SCHMIDT DISTRICT INFRASTRUCTURE

STORMWATER MANAGEMENT PLAN

ALL TERRAIN ENGINEERING PROJECT NO: 24013

EL PASO COUNTY REVIEW NO: CDR2413

FINAL GEC (3)

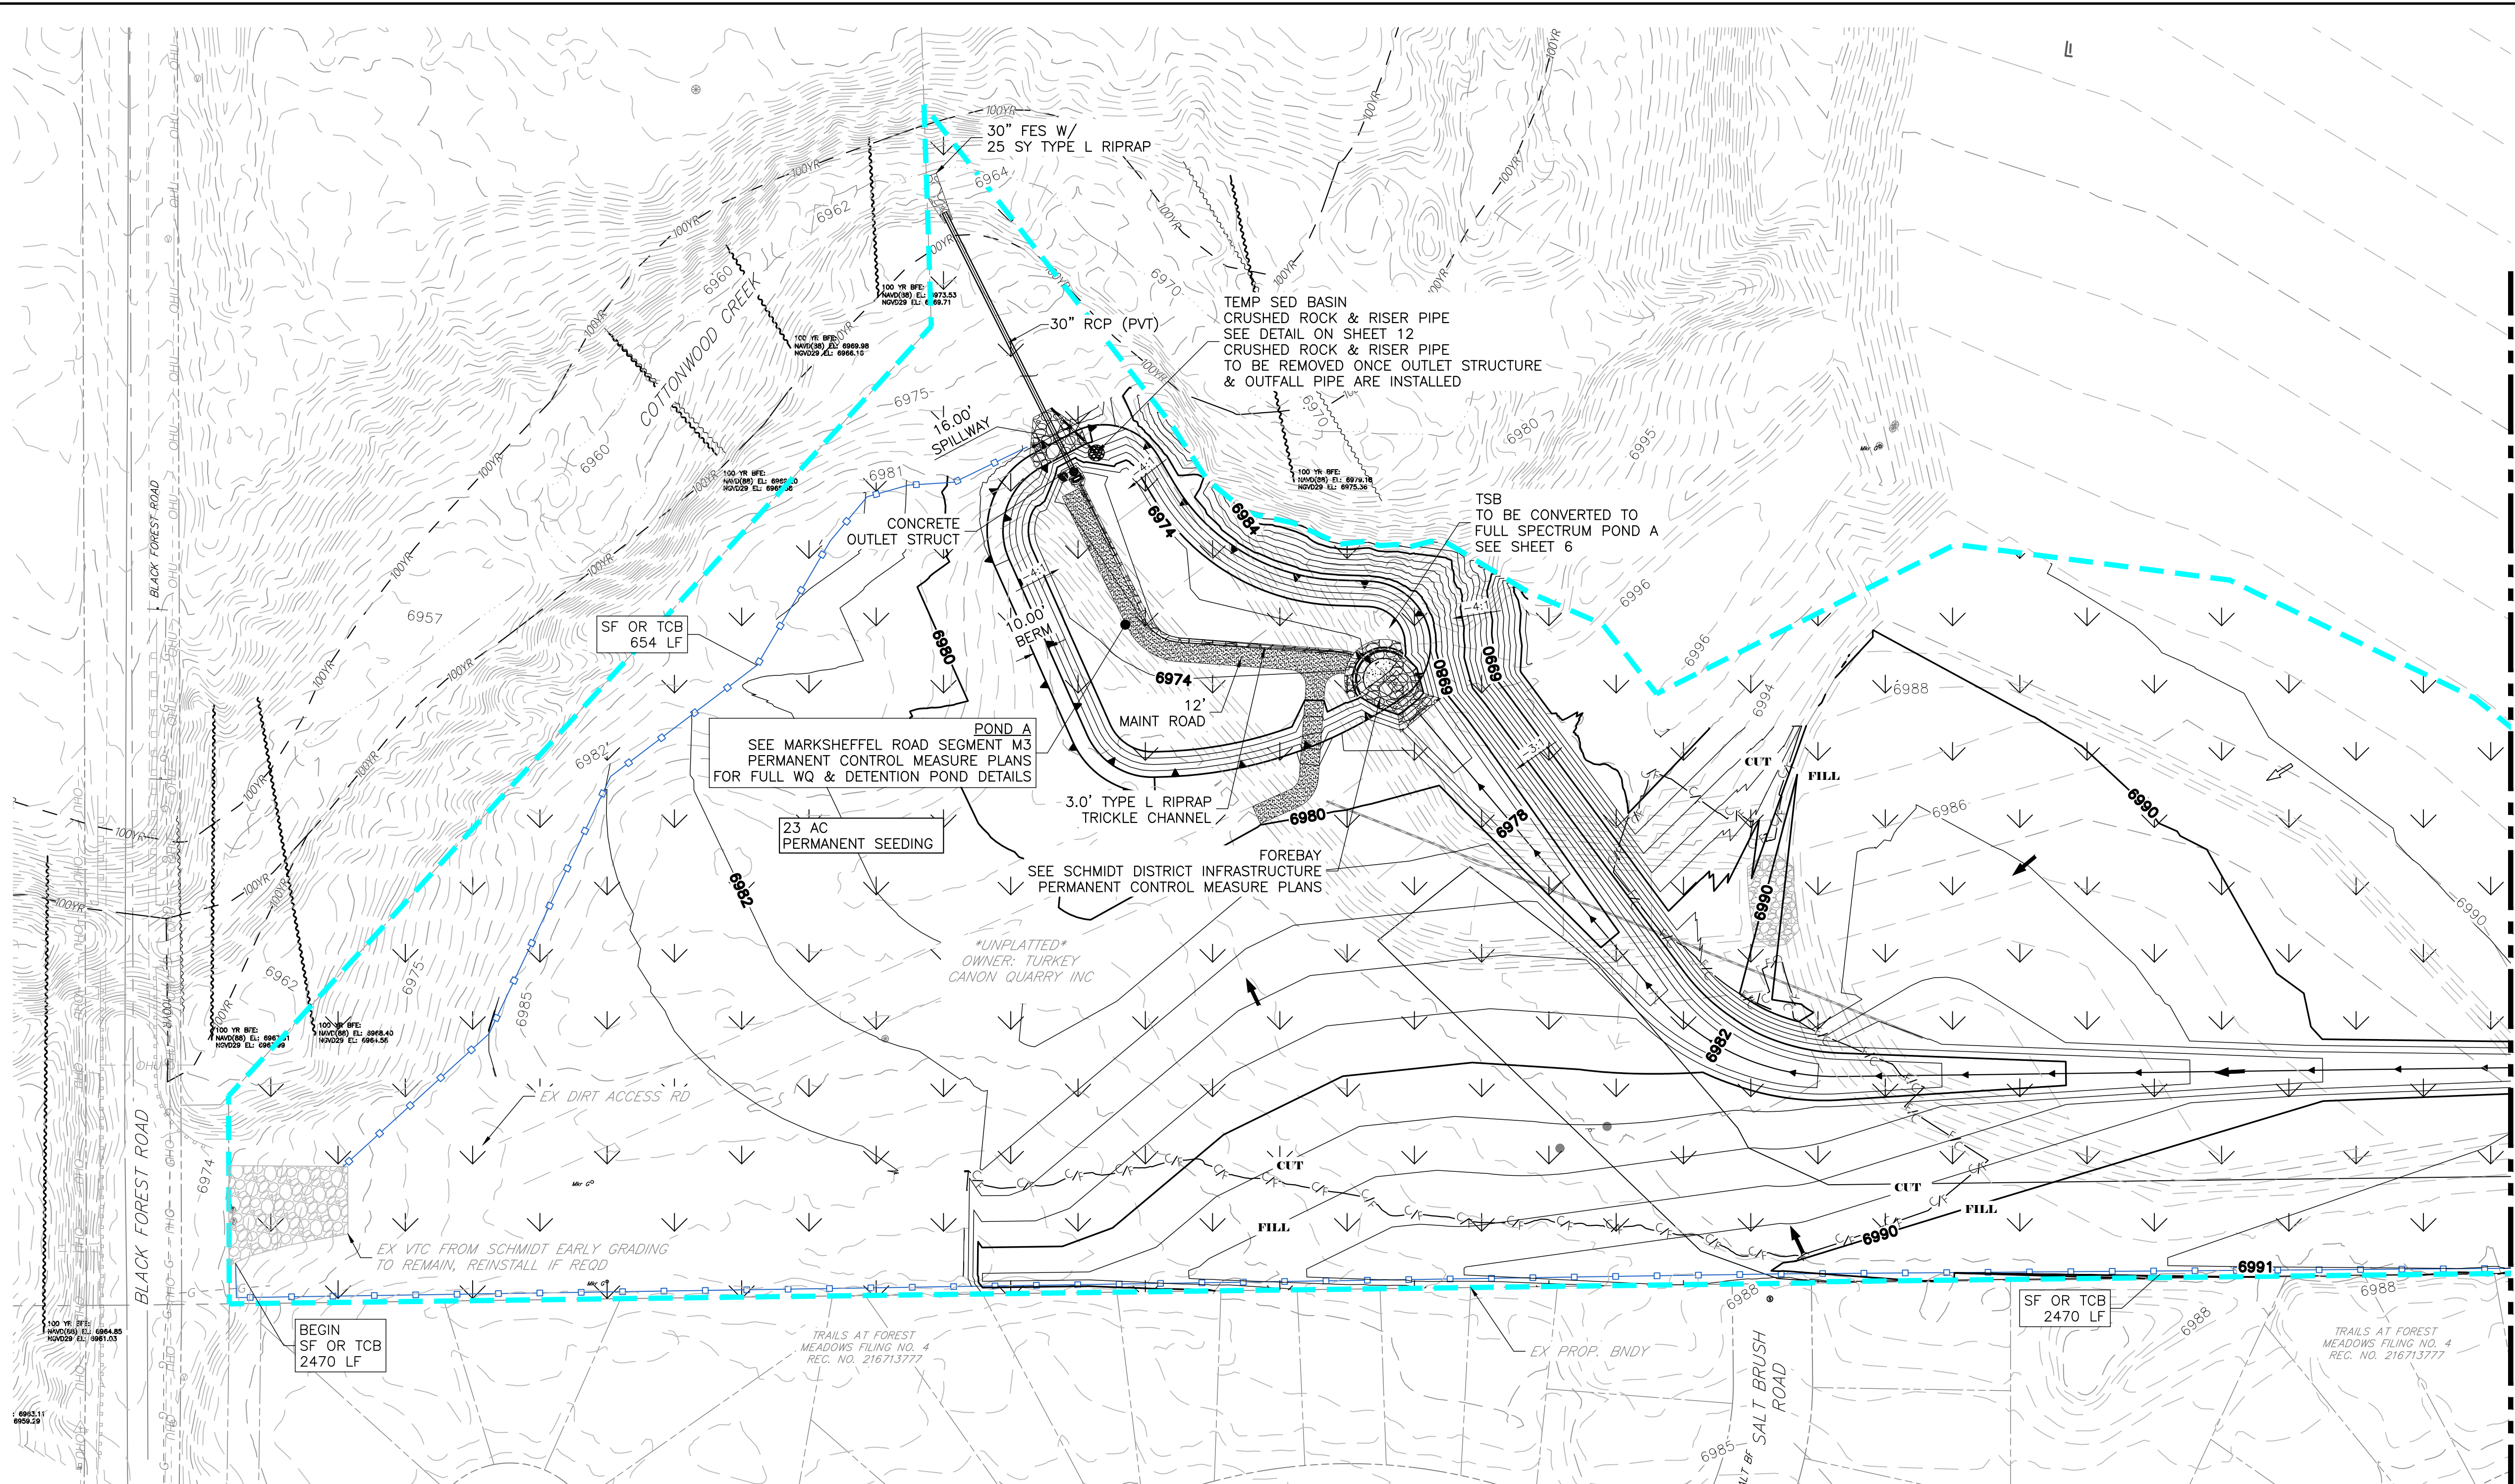
Item 18. Sediment control logs, rock socks and concrete washout area are shown on submitted GEC plan.

ATE: ADDRESSED, ITEM REMOVED.
